**RE: LIMITED DIAGNOSTIC AND TREATMENT FACILITY(F19-D17A). DRAINAGE
PLAN FOR BUILDING PERMIT AND SO#19 APPROVAL. ENGINEER'S STAMP
DATED APRIL 17, 1998.**

**SUBJECT: PRIVATE DRAINAGE FACILITIES WITHIN PUBLIC RIGHT-OF-WAY
DRAINAGE FILE NUMBER (F19-D17A).**

RE: LIMITED DIAGNOSTIC AND TREATMENT FACILITY (F19-D17A). GRADING AND DRAINAGE PLAN FOR BUILDING PERMIT APPROVAL. ENGINEER'S STAMP DATED APRIL 1, 1998.

RE: ENGINEER CERTIFICATION FOR LIMITED DIAGNOSTIC AND TREATMENT
FACILITY (F19-D17A) CERTIFICATION STATEMENT DATED 9/24/98

C-2

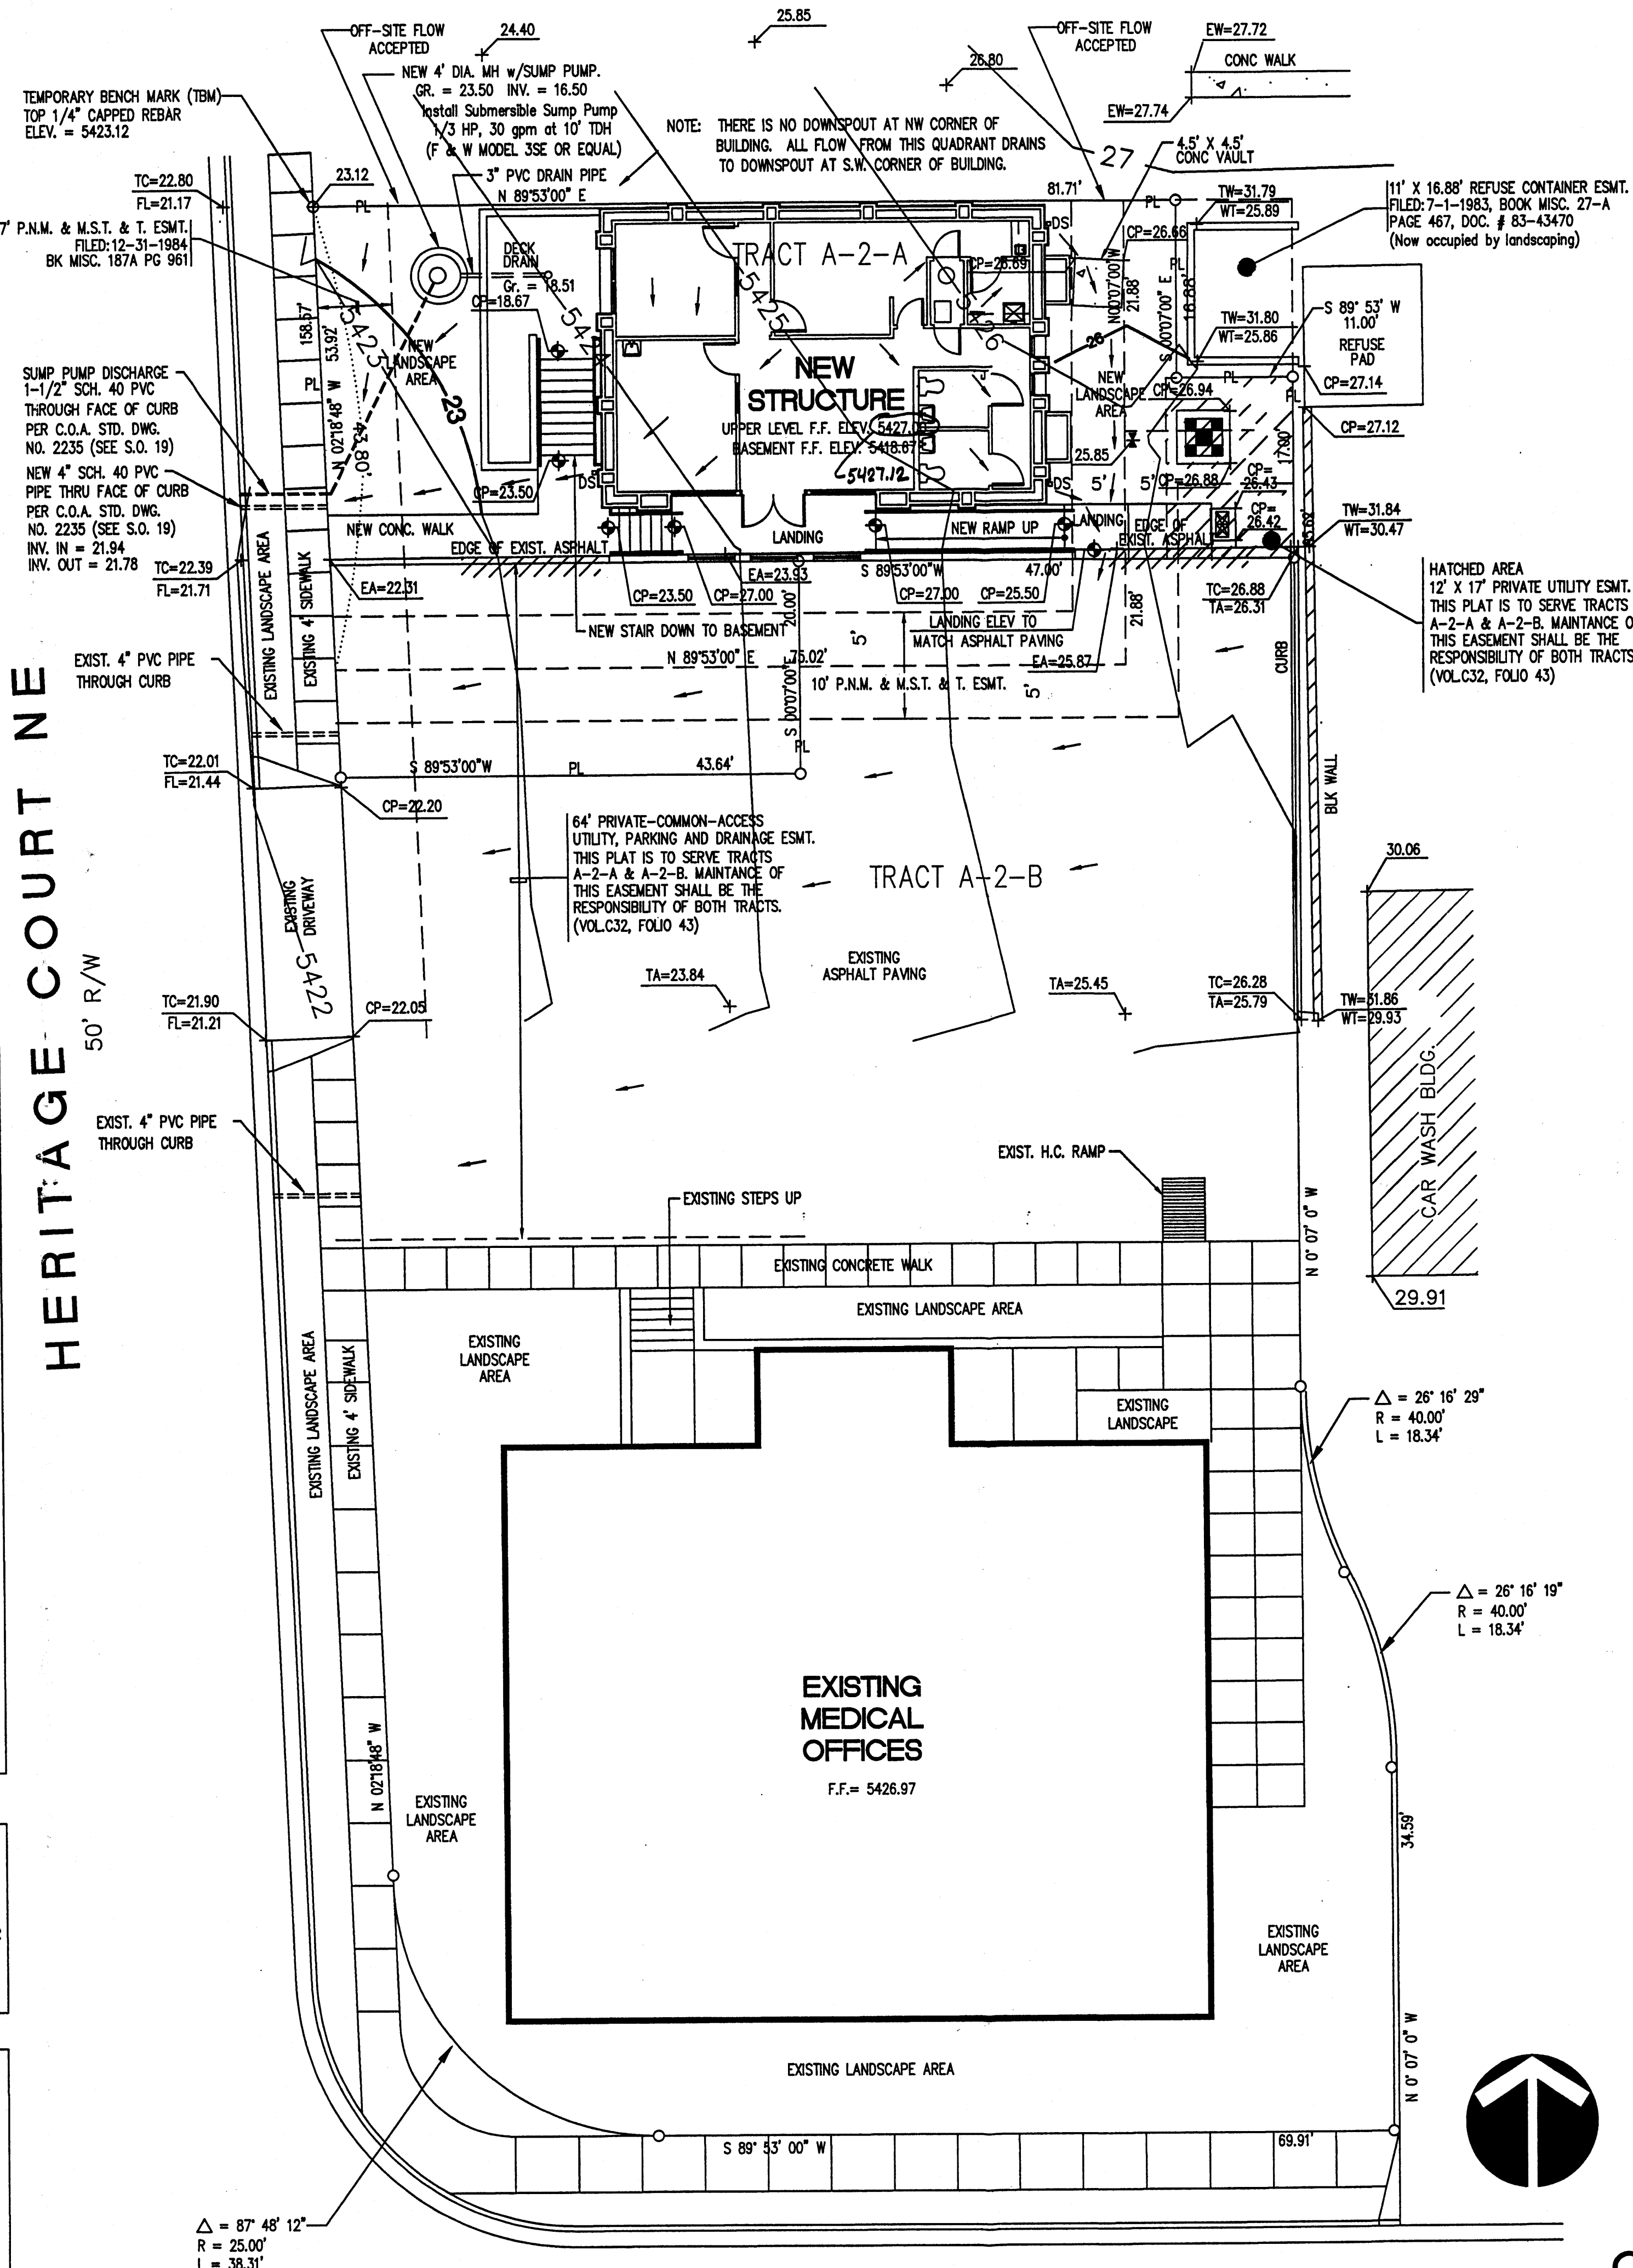
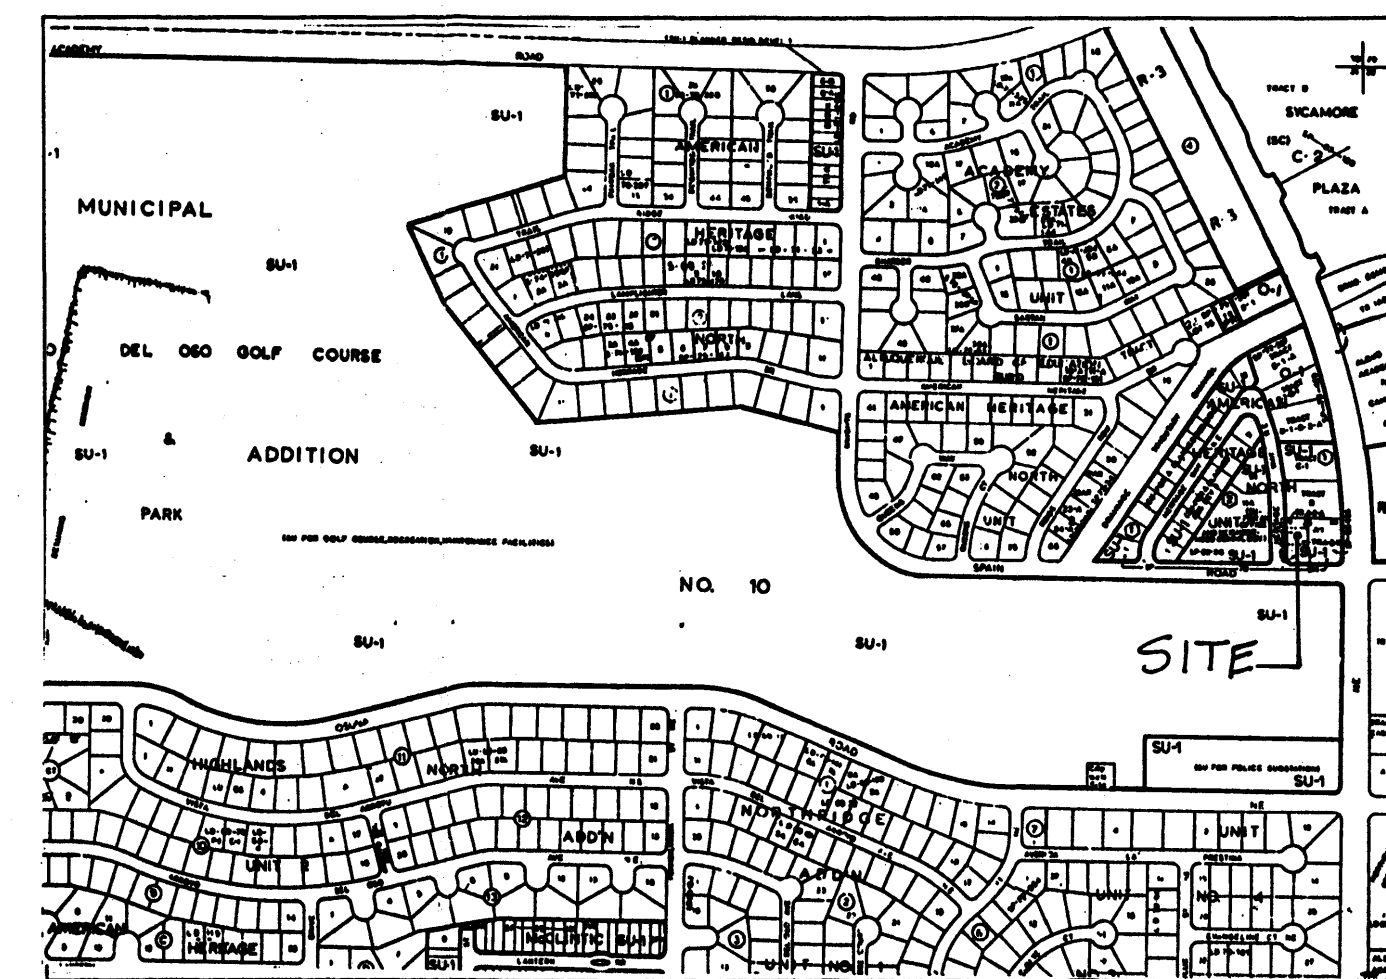
Based on the information provided on your September 24, 1998 submittal, the above request for approval for Certificate of Occupancy is denied at this time because of the following concern:

1. The proposed 4" pvc pipe through the curb must be installed. No developed run-off is allowed over a Public Sidewalk.

Please have the contractor obtain a permit to construct the 4" pvc, have it inspected and approved and then recertify.

The new 4" PVC pipe under the sidewalk and through the curb was not installed. The area drained is a landscaped area that is flush with the sidewalk and there is no point of concentration so the pipe is not needed.

SHEET NO.  
C-2

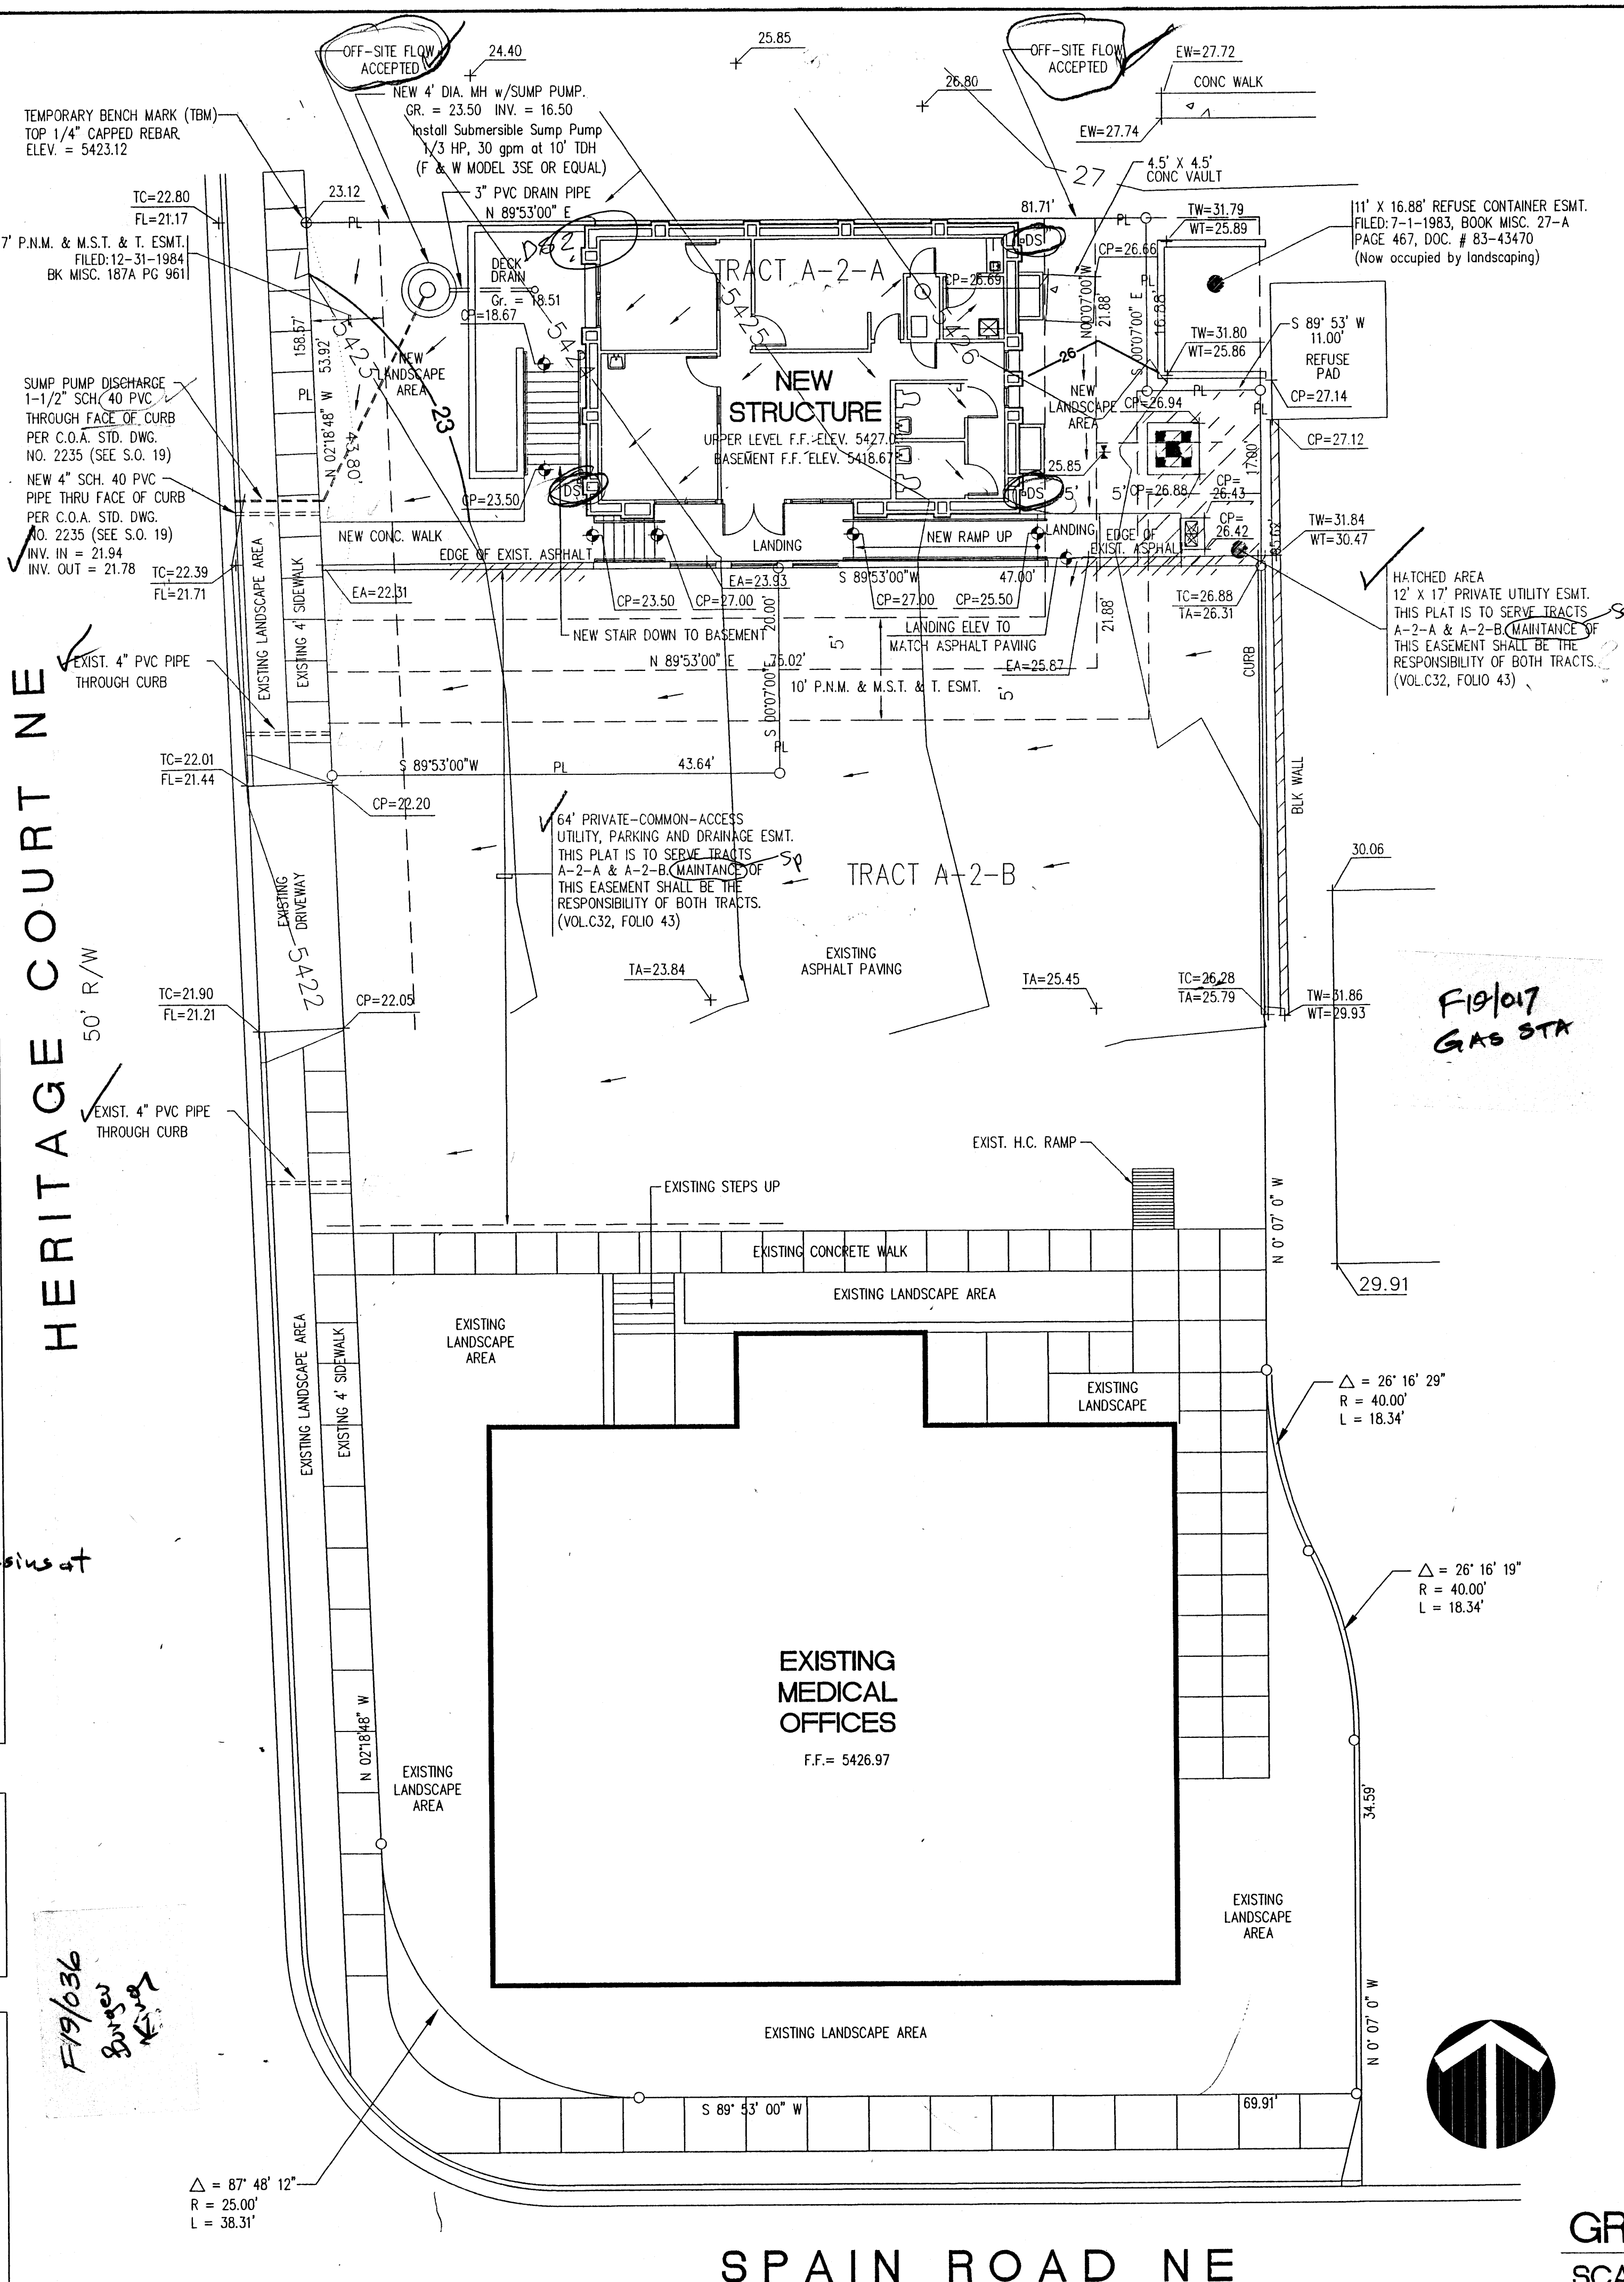
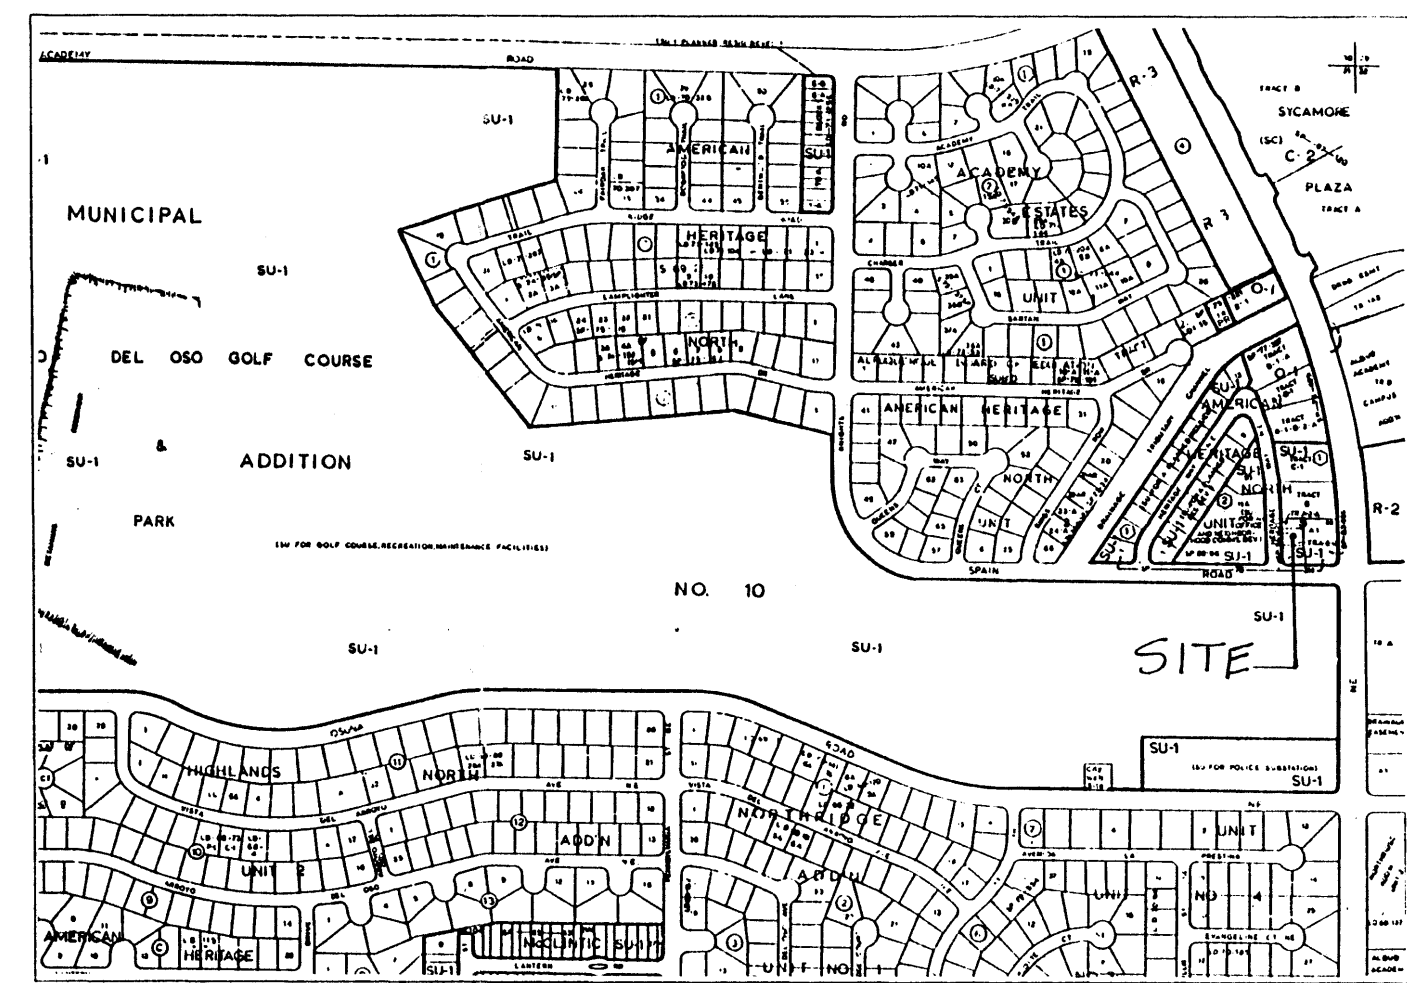
Based on the information provided on your April 1, 1998 submittal, the following corrections need to be made to the Drainage Calculations (notes) prior to final approval for the Building Permit and S.O.# 19 :

1. Under Proposed Conditions, add "Tr. A-2-A" to last sentence.
2. Under Off-Site Flow, etc. change "Wyo. Blvd." to "Heritage Court".
3. Under Analysis Of Downstream Conditions delete "only" before 0.19 cfs; "250 feet" should be "150 feet" (or so); after 650 feet add "to catch basins at".
4. Under Drainage Of Deck Drain: "cf" should be "sf".
5. Under General Notes: Correct BM Elev. It has an extra digit.
6. Indicate to where downspouts drain. Is there one at the N.W. corner?
